Re: Matthews Ridge Amenity Center and Pool

This department has reviewed the plans you submitted for the Matthews Ridge swimming pool to be constructed at 369 Chestnut Oak Ln., Lillington, NC. This plan review was conducted in accordance with the current North Carolina Rules Governing Public Swimming Pools (15A NCAC 18A .2500).

WATER SUPPLY PLAN: SCALE - 1/4" = 1' 0" 2

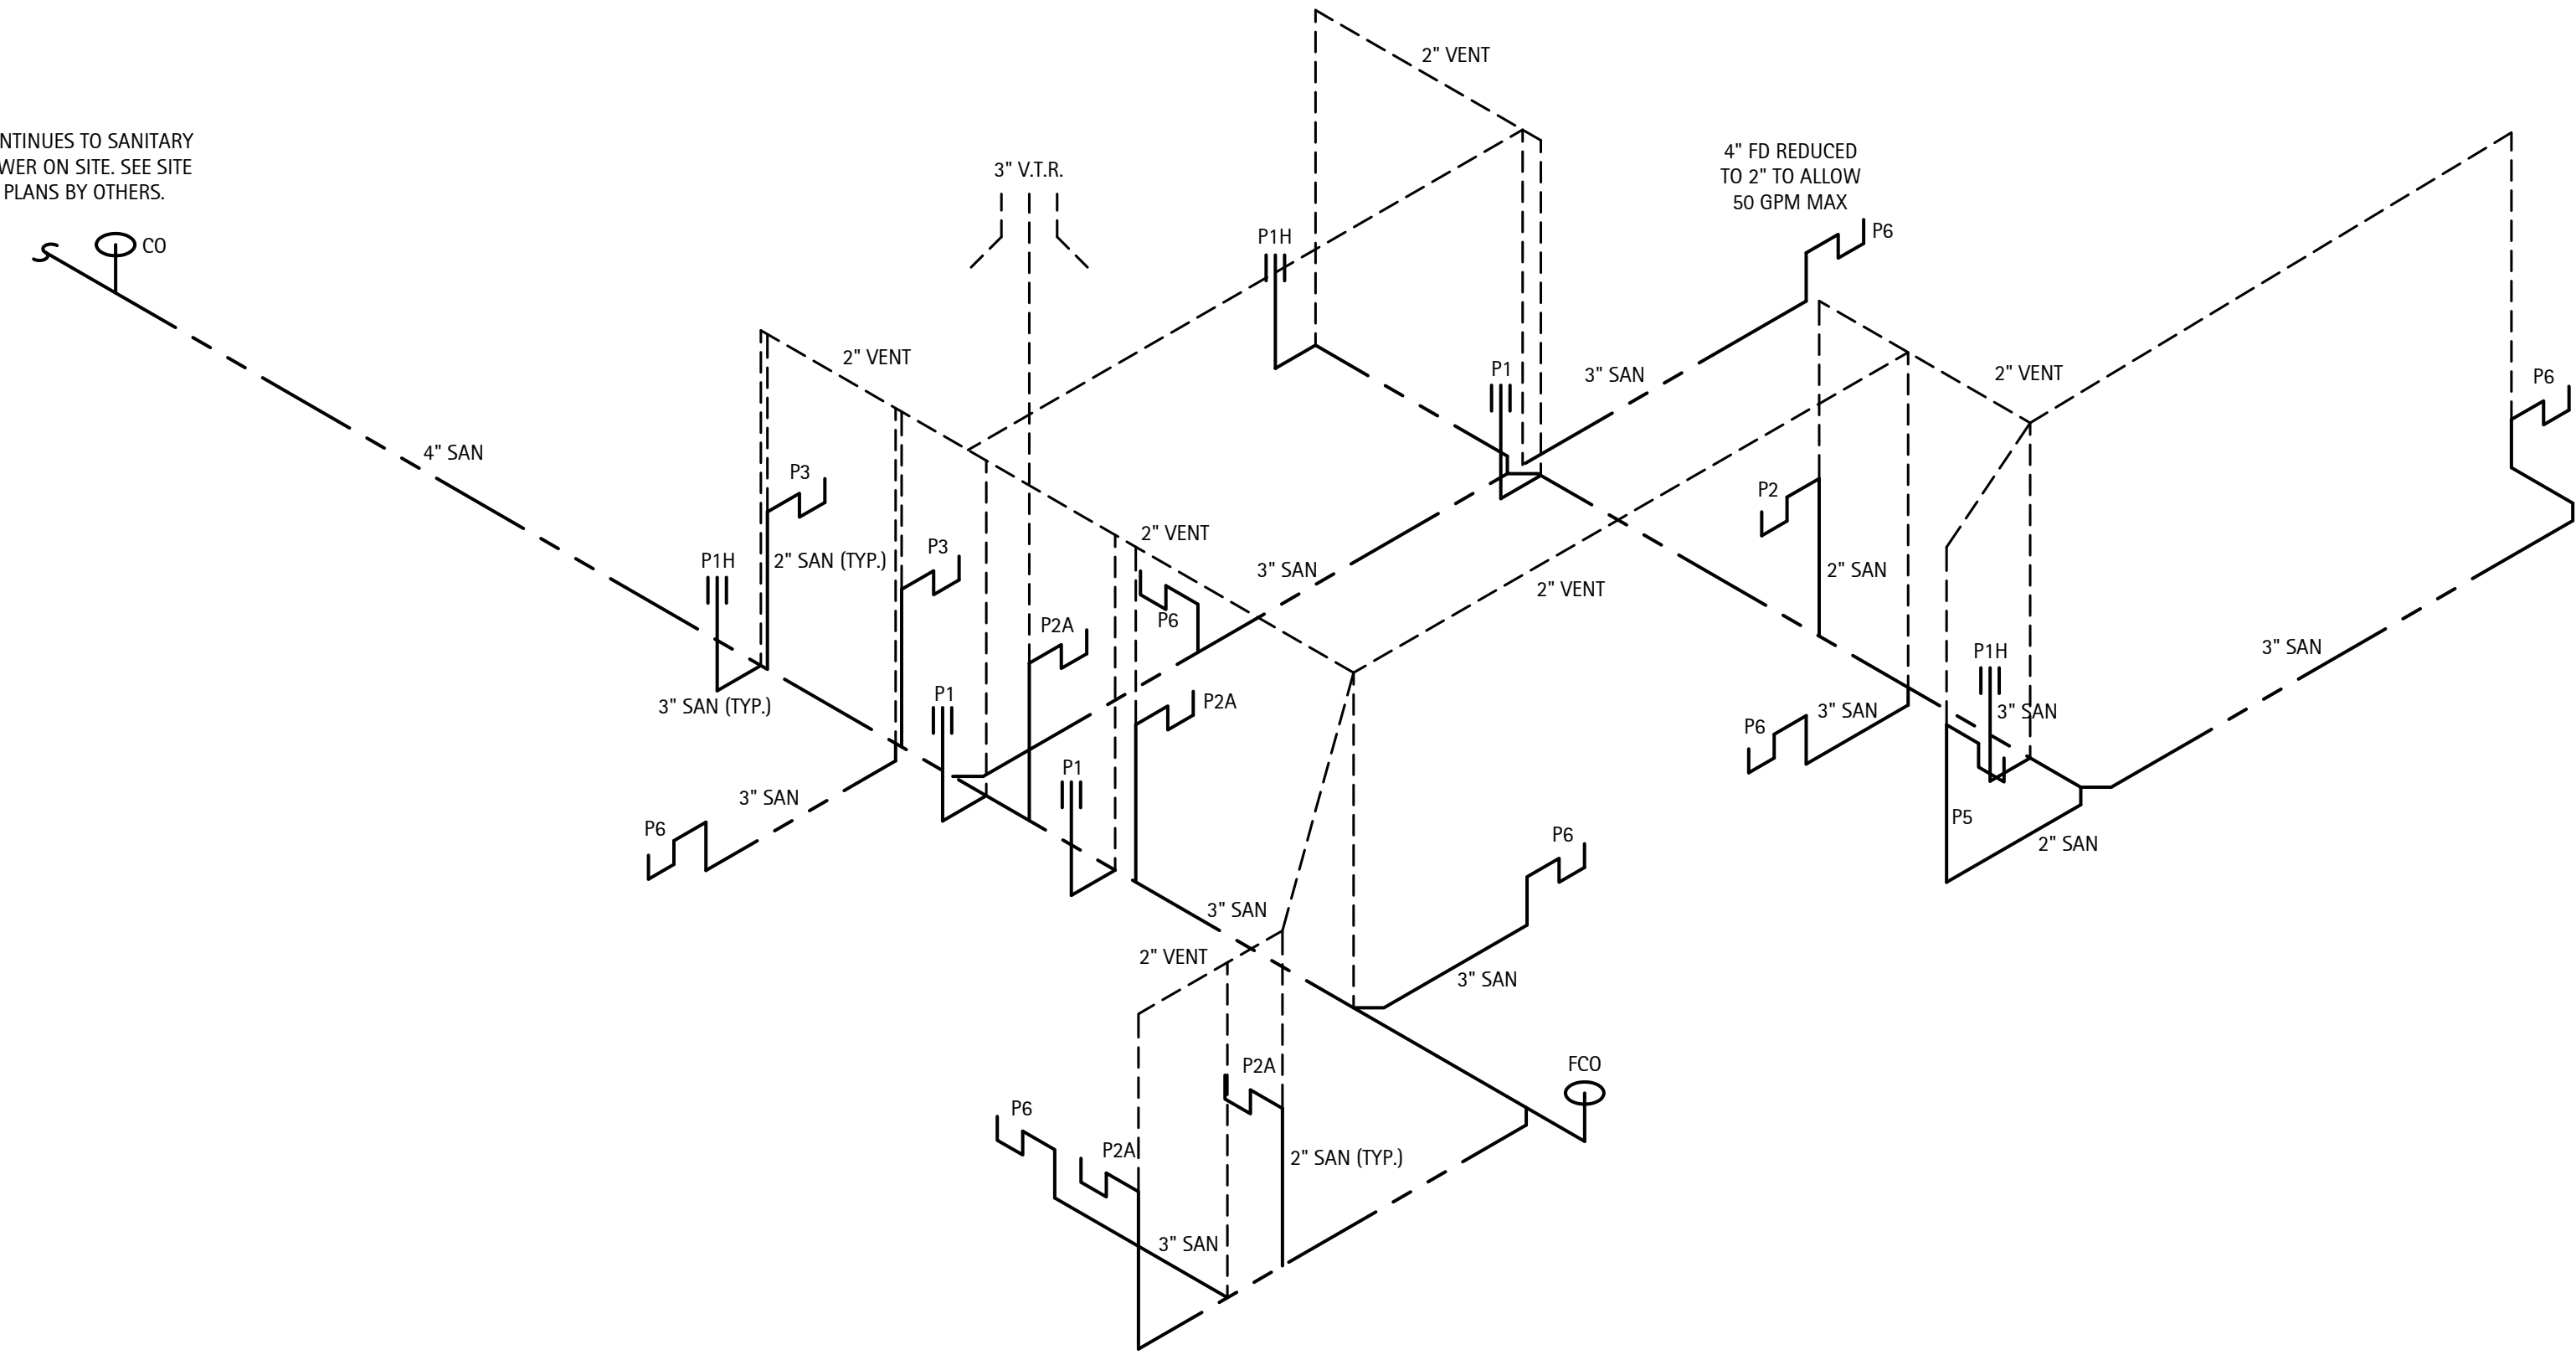
-The yard hydrant as shown on page SP3.0 shall be located so as to allow all areas of decking to be reached with a 100' hose if this is the only provided hose bib. The yard hydrant shall also be located so as to not obstruct decking or be a foot hold. A hose bib is indicated with the rinse shower on page SP2.0 but not on other pages. No frostproof hose bib is indicated on the plumbing plan pages P1 and P2.
